Our ref: DOC20/917734

Senders ref: SSD 10422

Subject: EES Comments - New Berrima Brickworks SSD 10422 - 416 & 524 Berrima Road, Moss Vale – Response To Submissions

Figure 3. Vegetation communities within the study area

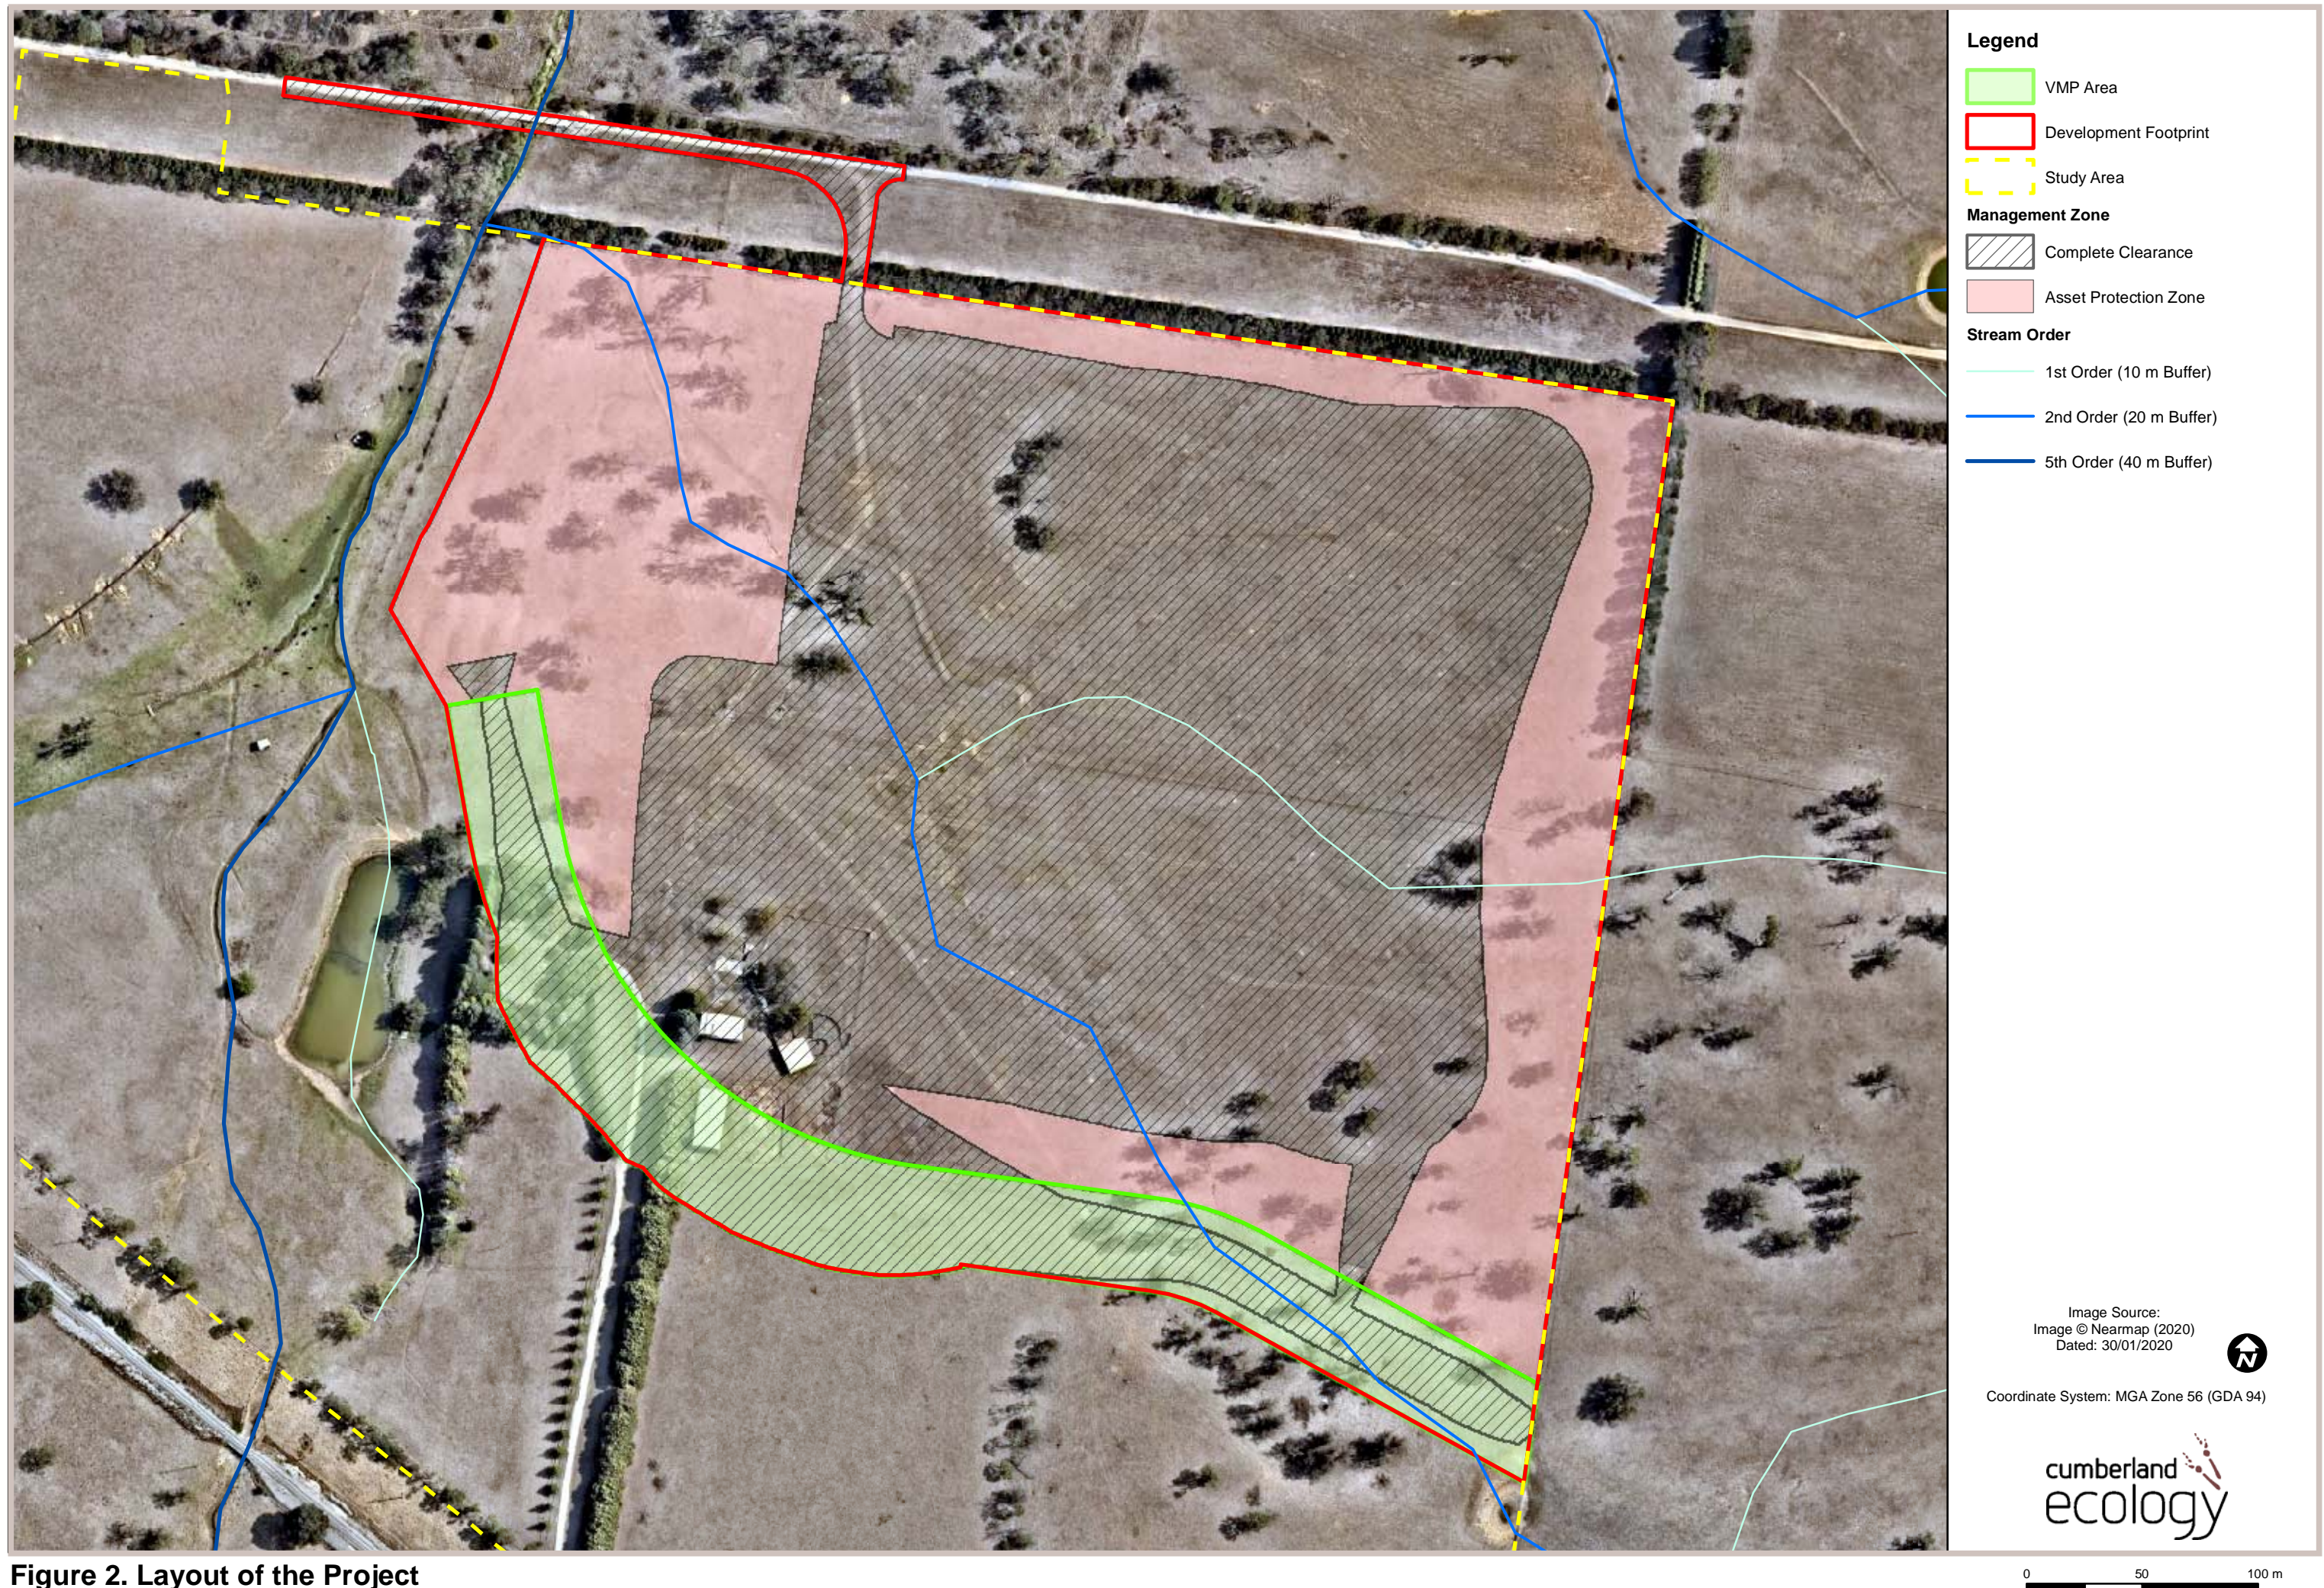
- Figures 3 and 8 of the BDAR indicate that “complete clearing” will occur in the Vegetation Management Plan (VMP) area. It is noted that this area is to be wholly revegetated with Southern Highlands Shale Woodland threatened ecological community. We therefore suggest retaining the existing paddock trees in the VMP area where possible, particularly as many of these existing trees are outside the proposed asset protection zone.
